**CITY OF PORTLAND, MAINE
DEVELOPMENT REVIEW APPLICATION
PLANNING DEPARTMENT PROCESSING FORM
D.R.C. Copy**

Application Date
Wyoming Ave. - #35 (lot #29)
Project Name/Description
35 - 35 Wyoming Ave, Portland, Maine
Address of Proposed Site
400-B-015
Assessor's Reference: Chart-Block-Lot

CITY OF PORTLAND, MAINE
DEVELOPMENT REVIEW APPLICATION
PLANNING DEPARTMENT PROCESSING FORM
ADDENDUM

TO: Inspections
FROM: Jay Reynolds, Development Review Coordinator 
DATE: July 30, 2001
RE: C.O. inspection for 35 Wyoming Avenue
(CBL 400 B 015) (2001-0025)

Conceptual Grading Plan ; Scale 1"=30'
 Lot 29 Pines @ Wyoming
 (35 Wyoming Ave)
 Plot Plan Prepared By Greg McCormack 2/19/01
 Based on Grading Plan Prepared By Pinkham +
 Greer Engineers Dated September, 1999

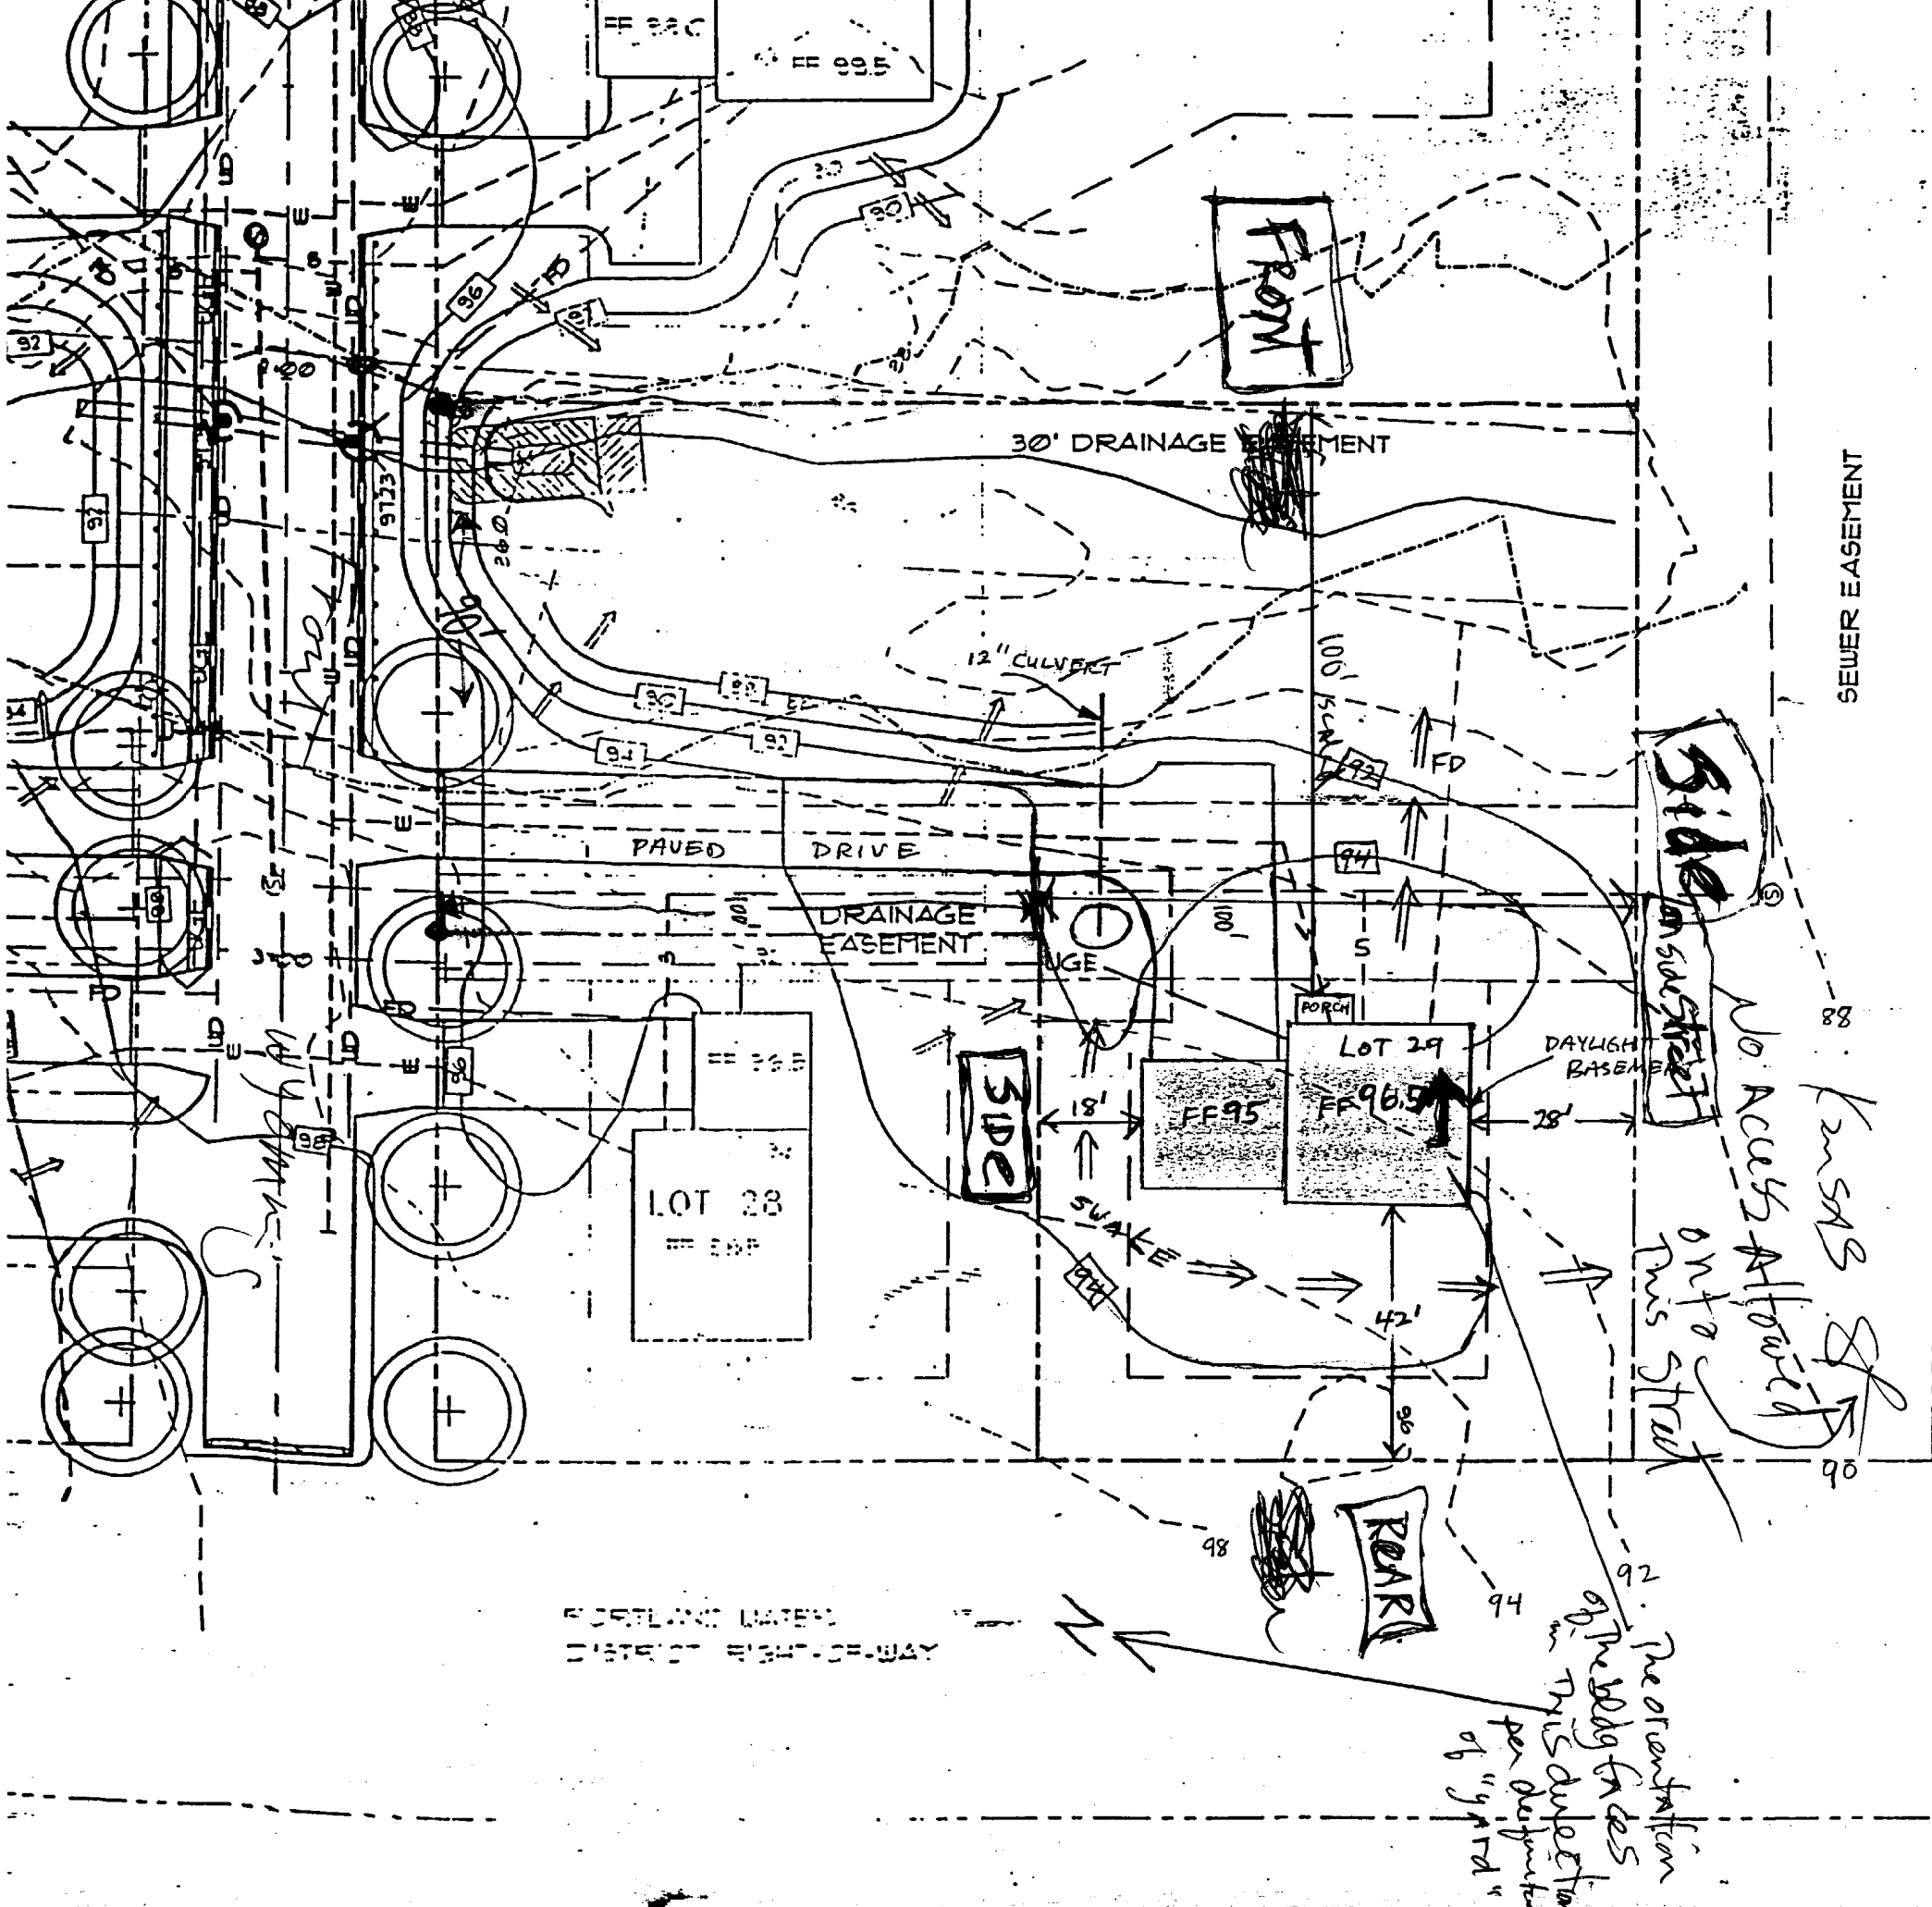
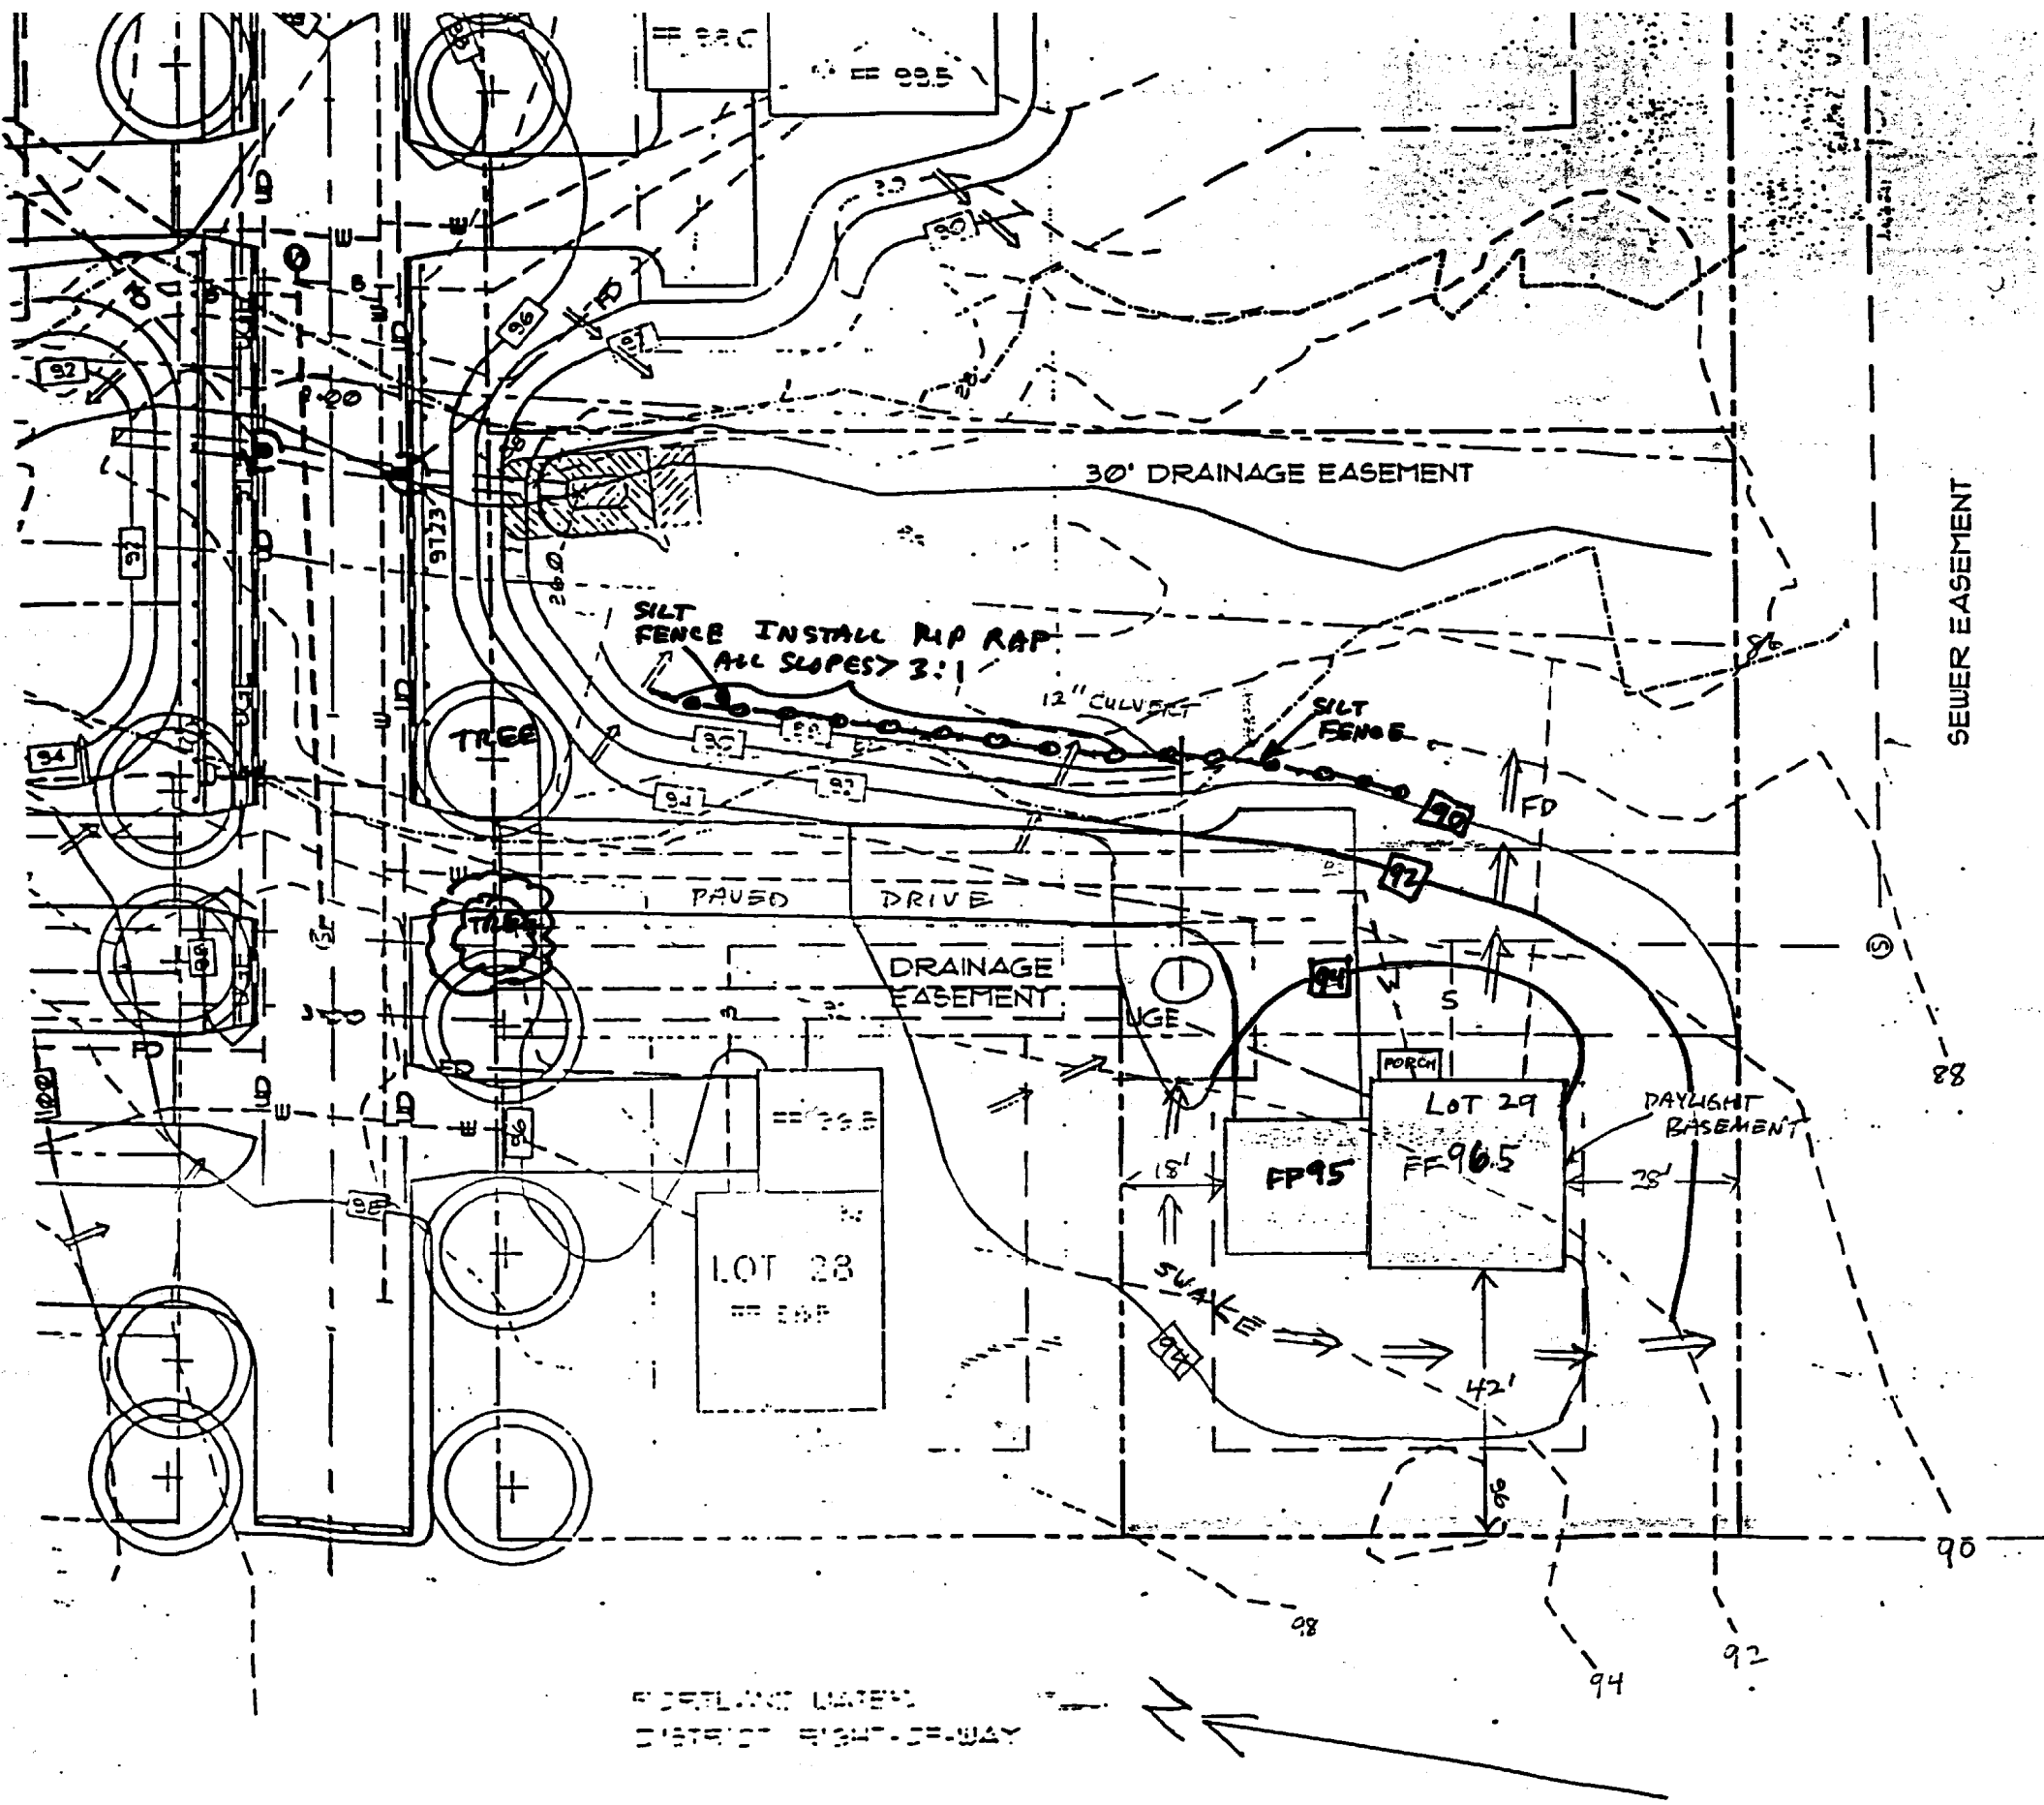
A drainage plan shall be submitted to and approved by Development Review Coordinator showing first floor elevation (FFE), sill elevation (SE), finish street/curb elevation, lot grading, existing and proposed contours, drainage patterns and paths, drainage swales, grades at or near abutting property lines, erosion control devices and locations and outlets for drainage from the property.

Applicant shall install silt fence along the southerly lot line, at the discretion of the Development Review Coordinator.

All slopes on this lot greater than 3:1 shall be rip-rap. This is not limited to the area shown on the approved site plan.

- Revised 2/26/01: Provide / Change Grading in
- front of house < 3:1 slope.
 - Install Rip Rap all slopes > 3:1 east side of driveway.
 - Plant / or conserve (2) trees by street.
 - Install silt fence as shown
